**Application no:** H23-0876-10

**Description:** Proposed replacement dwelling

**Location:** The Bungalow  
Common Road  
Whaplode Drove  
Spalding Lincs  
PE12 0UF  
PE12 0UF

# AMENDMENT RECORD SHEET - LIVE APPLICATION

Drawing Number:
10/254/PA/003

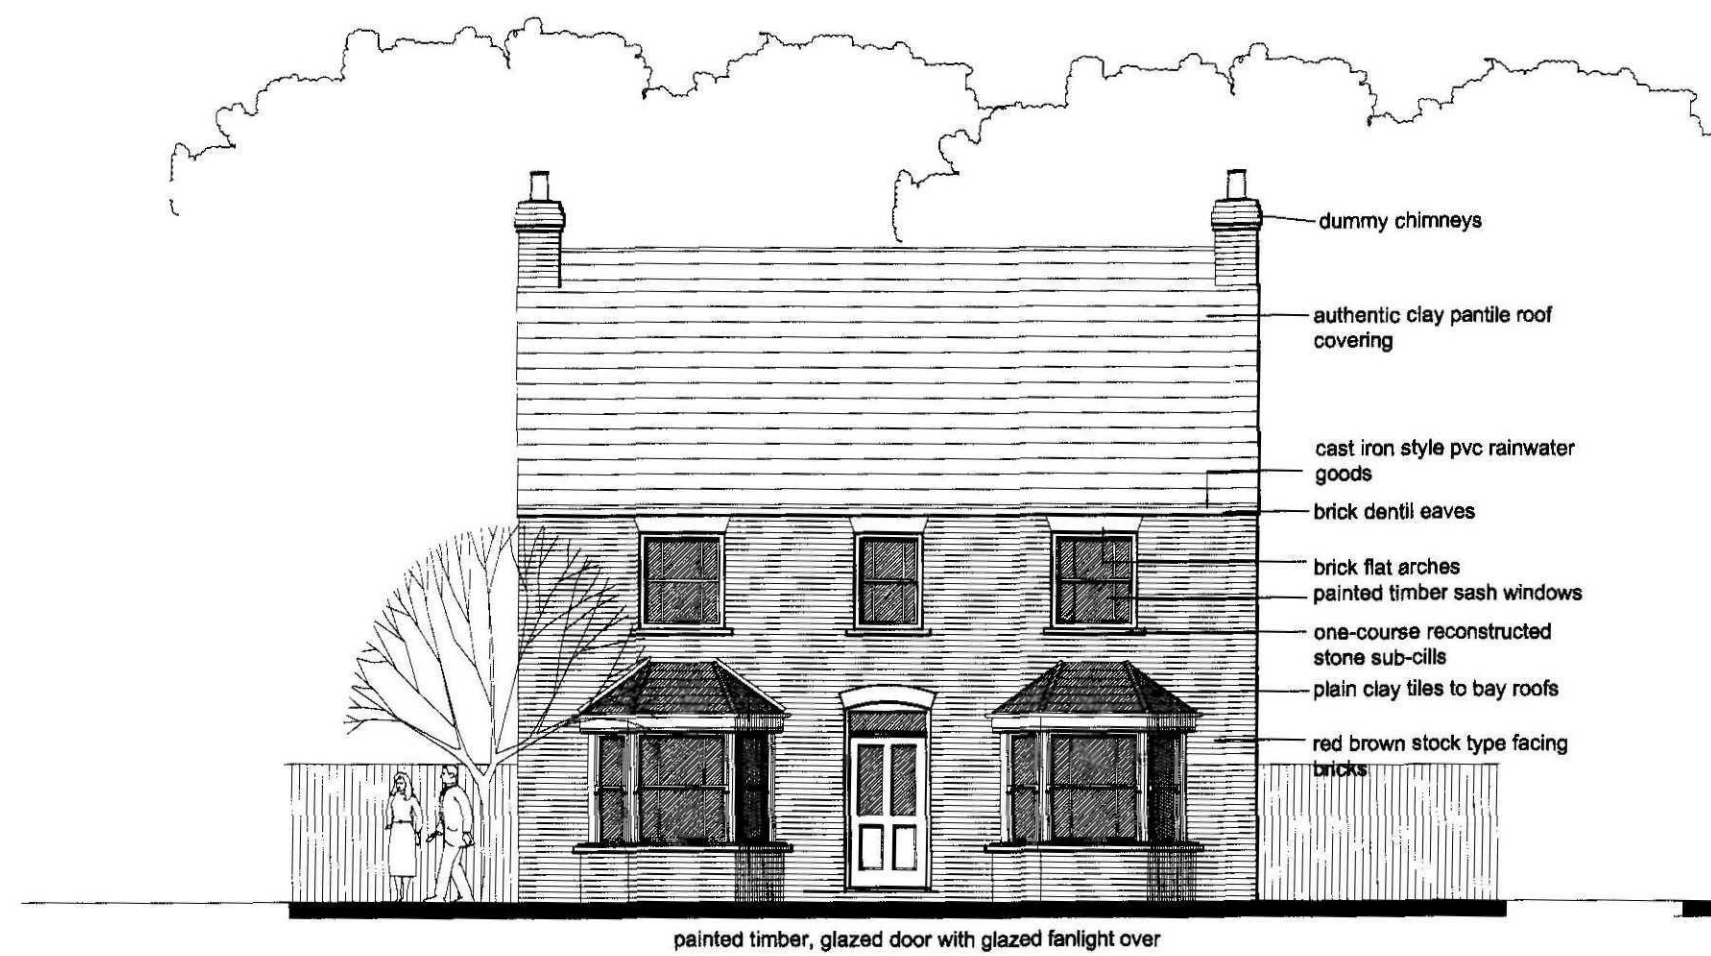
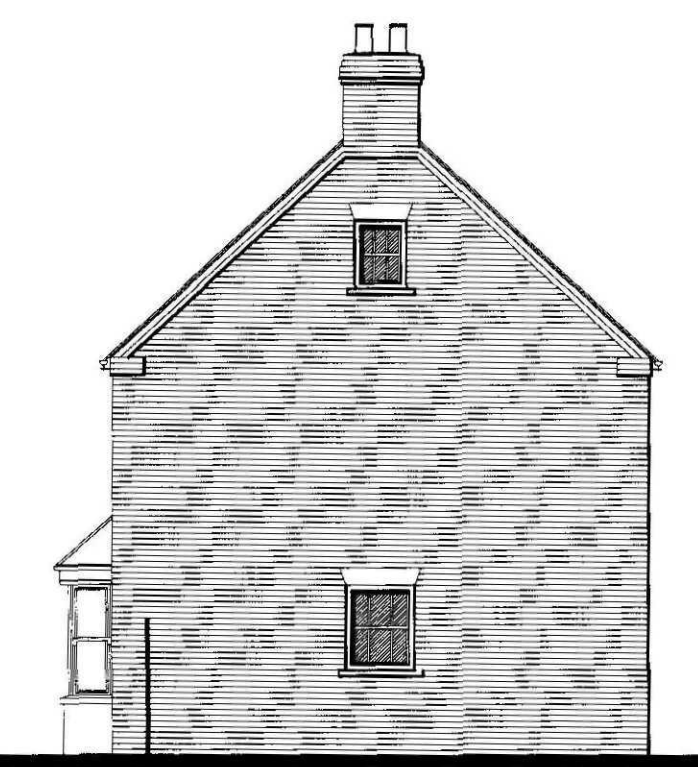
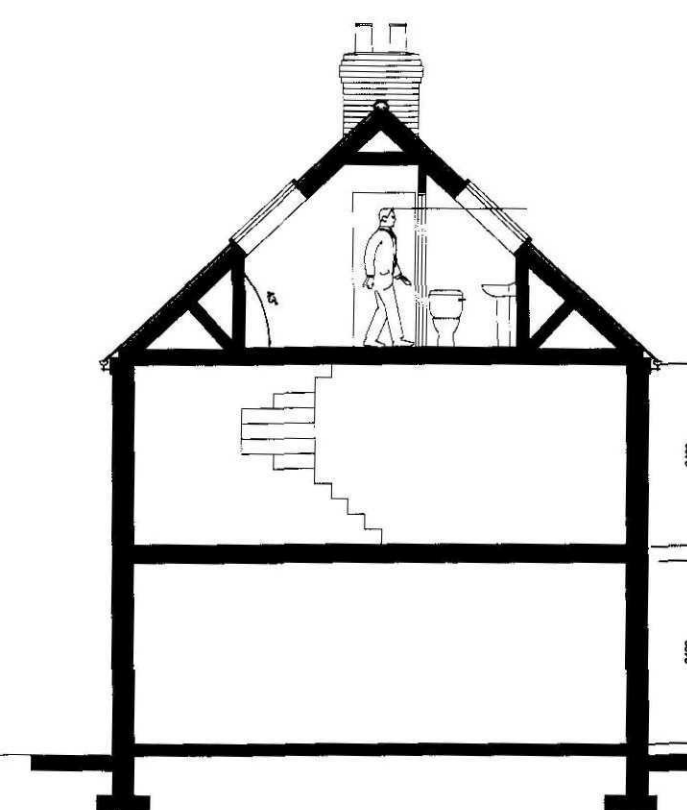
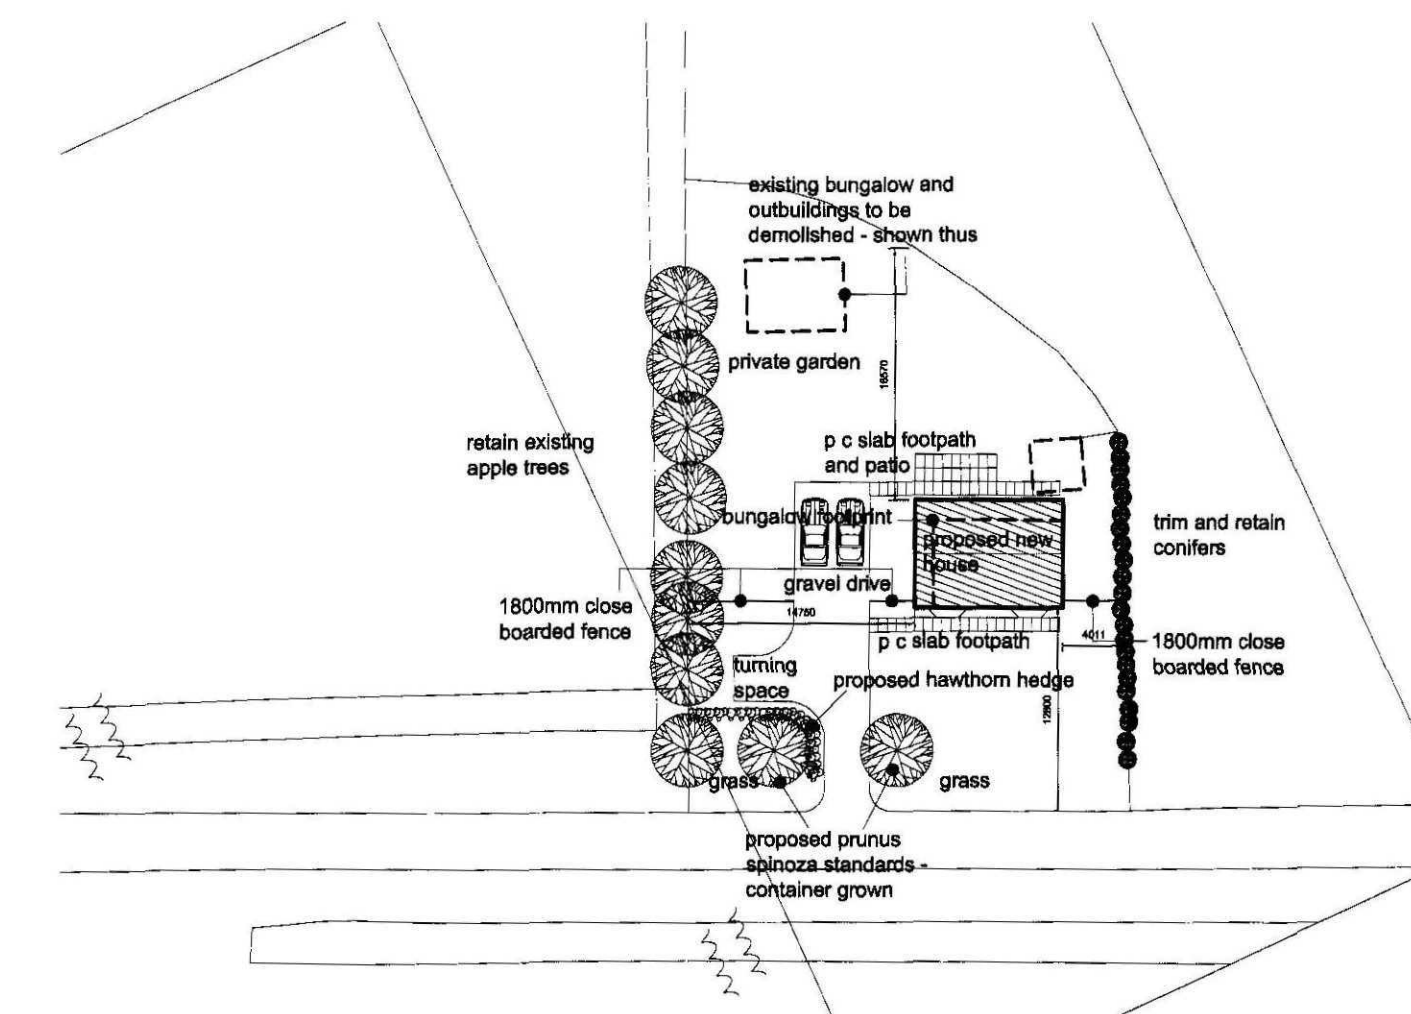
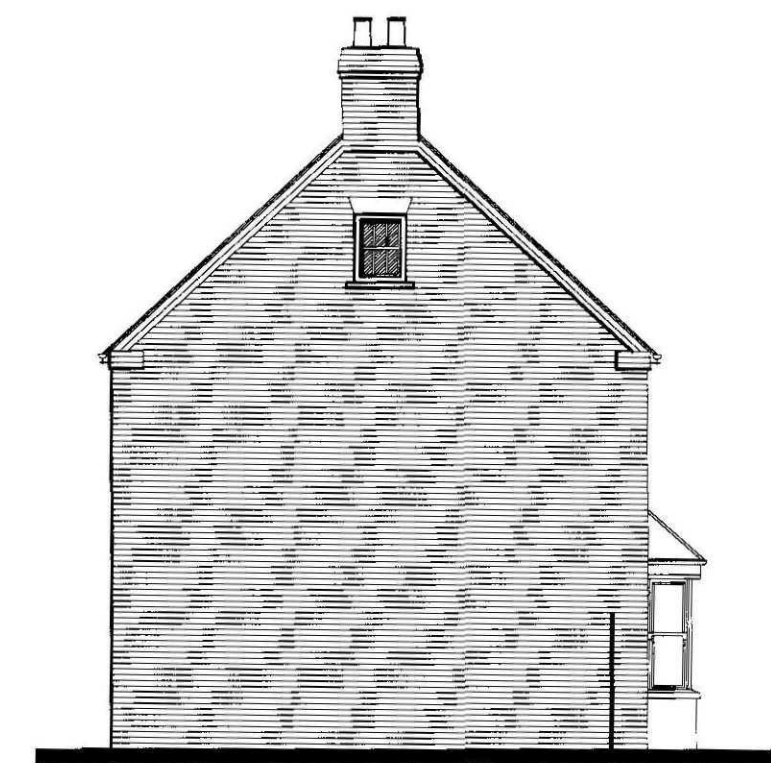
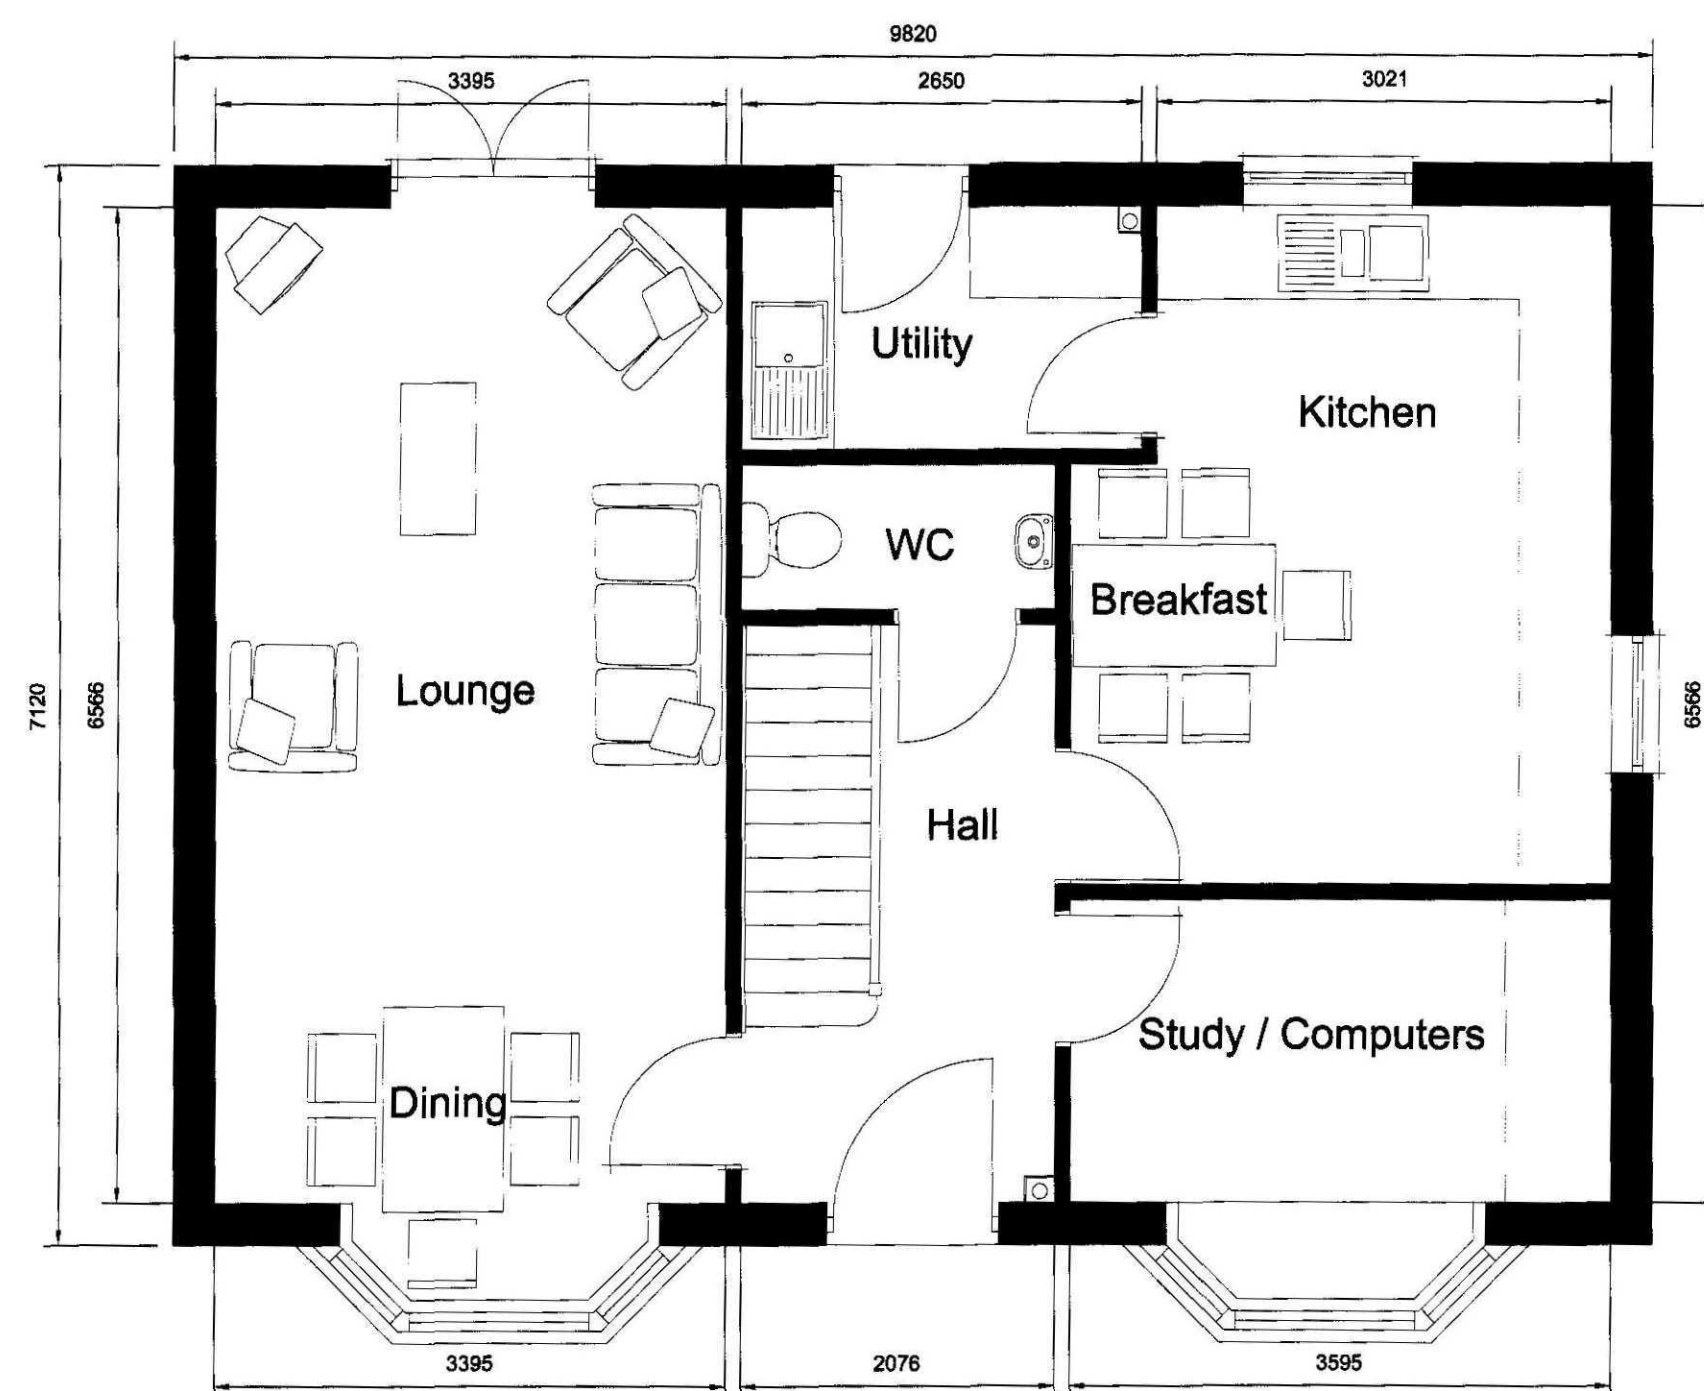
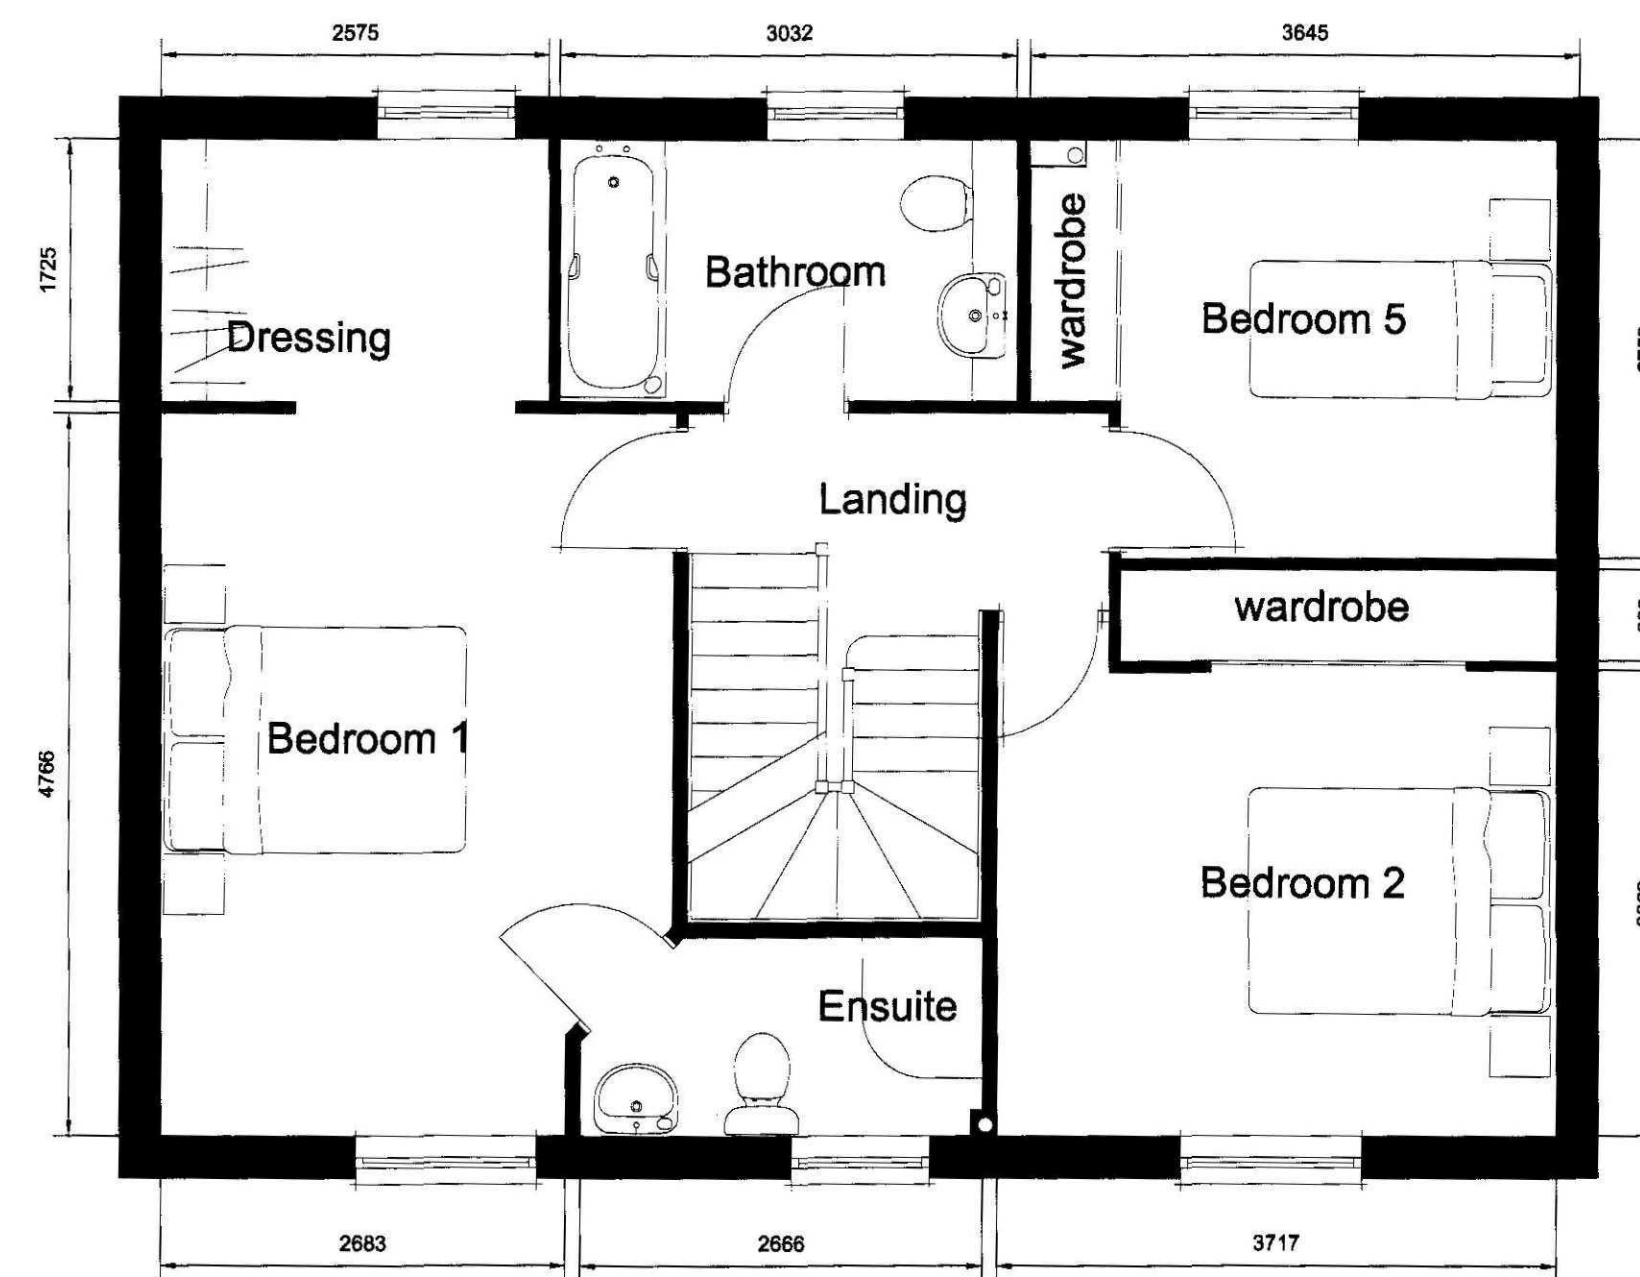
In accordance with the above, a number of revisions are therefore required to make the development more acceptable. The dormer at the rear in particular is unacceptable and should be omitted. The number of rooflights on the front elevation is also excessive - the middle one should be deleted. Whilst we are somewhat more relaxed in respect of the rear elevation, the window on the side elevation should have a greater vertical emphasis.

The external roofing material to be used for the main roof and bays will need to be a traditional material and not concrete.

I have now modified the drawing according to your wishes, and attach a copy for your comments. I believe that I have addressed the dormer issue and have reduced the Velux type windows also, taking them off the front elevation completely. I have added two small windows in the gables and trust that you will not have a problem with these. I have also changed the roof covering specification, and have slimmed down the ground floor gable window.
